Our Case Number: ABP-310286-21

Re: Railway works and all works necessary to eliminate and, where necessary, upgrade seven numbered level crossings and carry out all associated and ancillary works along a 24-kilometre section of the Dublin to Cork Railway Line.
Fantstown, Thomastown, Ballyhay, Newtown, Ballycoskery (Ballyhea Village), Shinanagh and Buttevant, Co. Cork and Co. Limerick.

Railway Order – Dublin to Cork Railway Line (Eliminate and Upgrade of Level Crossings between Limerick Junction and Mallow) Order 2021 (XC201 Thomastown and the XC187 Fantstown)

Figure 2.3: XC187 Fantstown Proposed Solution

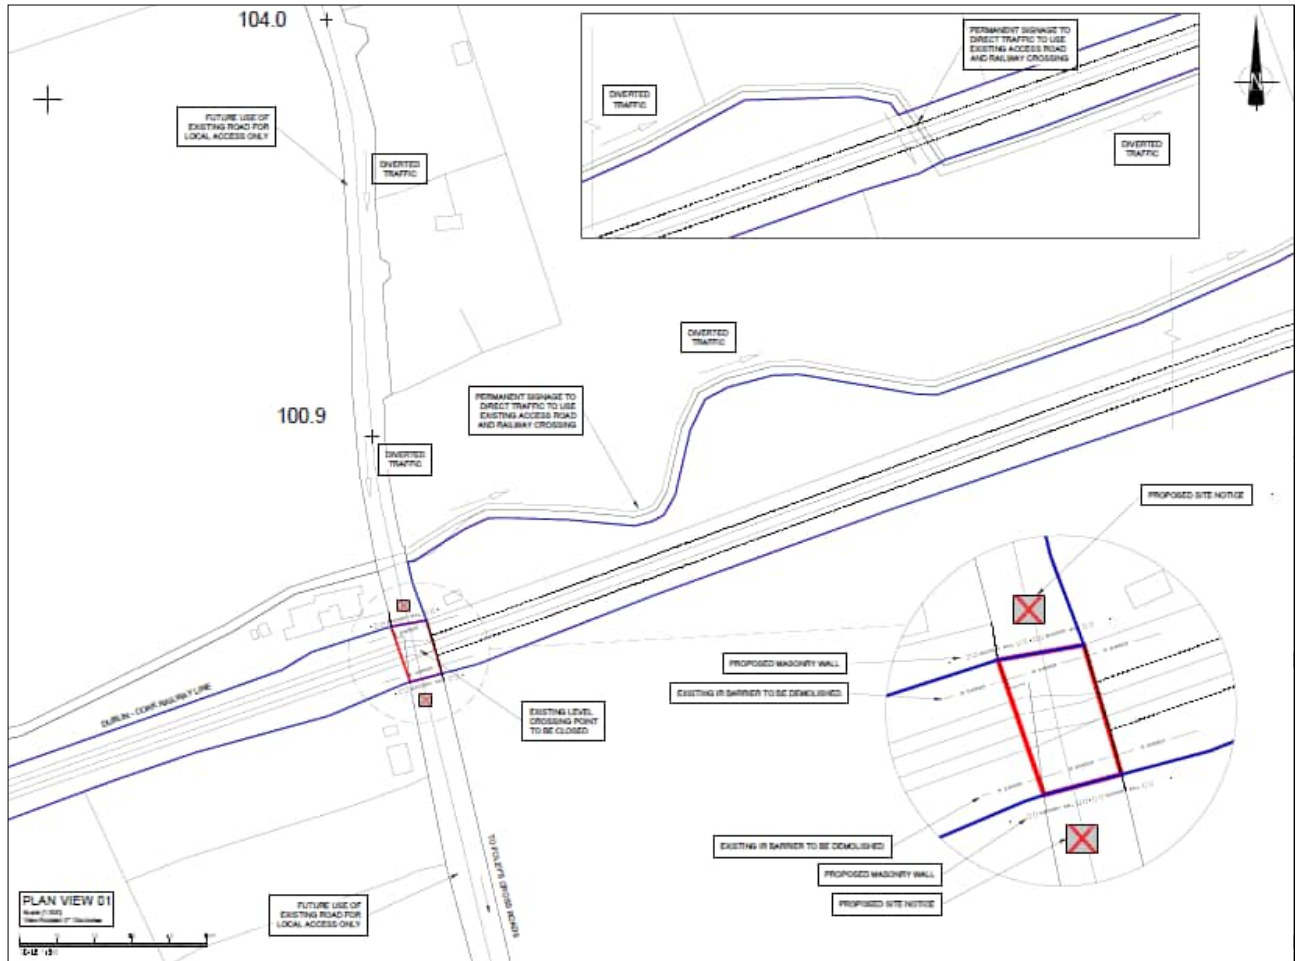
1. Division of the parish, including rural isolation.
2. Long delays and waiting times at the rail crossing.
3. The imminent closure would result in two cul de sacs.
4. Access for emergency services.

"That, we, the elected members of the Cappamore/Kilmallock Municipal District call on Irish Rail to reconsider its decision to close the Fantstown level crossing (XC187) permanently and replace the crossing with a bridge to link the community."

Figure 2.5: XC201 Thomastown Proposed Route Alignment

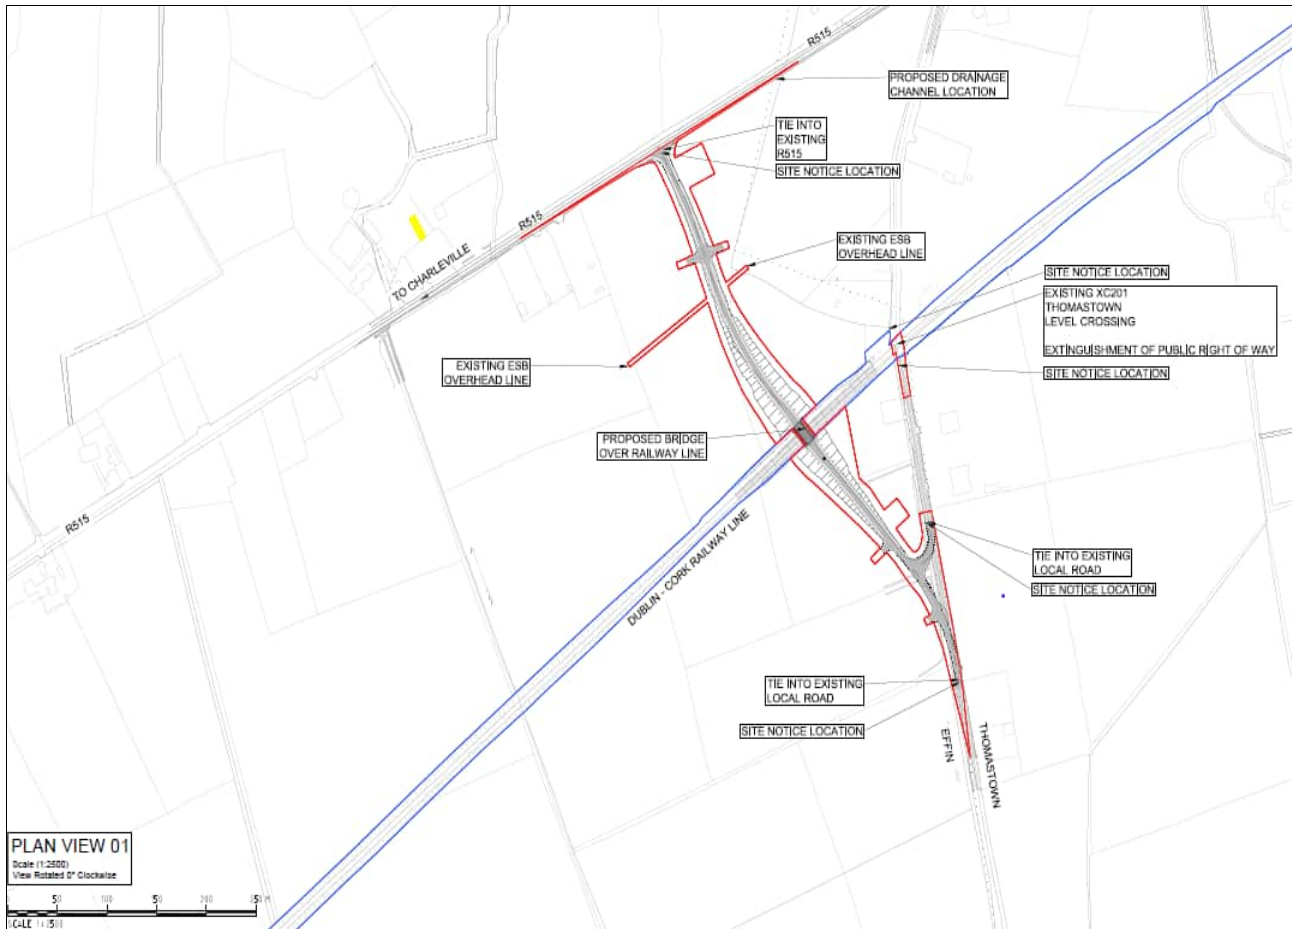
There are safety concerns with the width of the road, which is not wide enough for two vehicles to pass safely and as this is a rural area there are a number of farms in close proximity to the rail crossing with a significant movement of agriculture machinery, including milk trucks, animal feed deliveries, tractors etc. The volume of vehicles and agricultural machinery will also increase on this road especially during school times and harvesting season which further outlines the importance of having a wider two lane road.

The new junction planned for the Charleville - Kilmallock road (R515) needs to be reviewed as it will cause stacking of vehicles when turning off the R515 onto the new road. There has been a number of serious accidents on this road over the last 20 years, including fatalities.

The Effin community has been linked by the railway crossing for a long number of years and the amenities and services are all on the south side of the railway crossing. While the new bridge and access road is very welcome by the community, which was highlighted at our recent meeting with the residents, we, as elected members want to future proof the design of the new route to allow Limerick City & County Council upgrade the road on the south side at a later date.

"That, we, the elected members of the Cappamore/Kilmallock Municipal District call on Irish Rail for the design to include a single carriageway with 2 lanes and a pedestrian footpath on the new bridge proposed for Thomastown."

1. The bridge has to be a two-way carriage road with a pedestrian footpath.
2. Move roadway at north side close to the hedge which will suit the landowner and adjacent dwelling house.
3. Major concern the cul-de-sacs on both sides are secure from illegal camping, dumping and anti-social behaviour.
4. Disused road section to be banked up to prevent illegal camping and dumping.
5. Consult with residents on height of walls close to the existing railway gates
6. Ownership of 3 red areas drawings
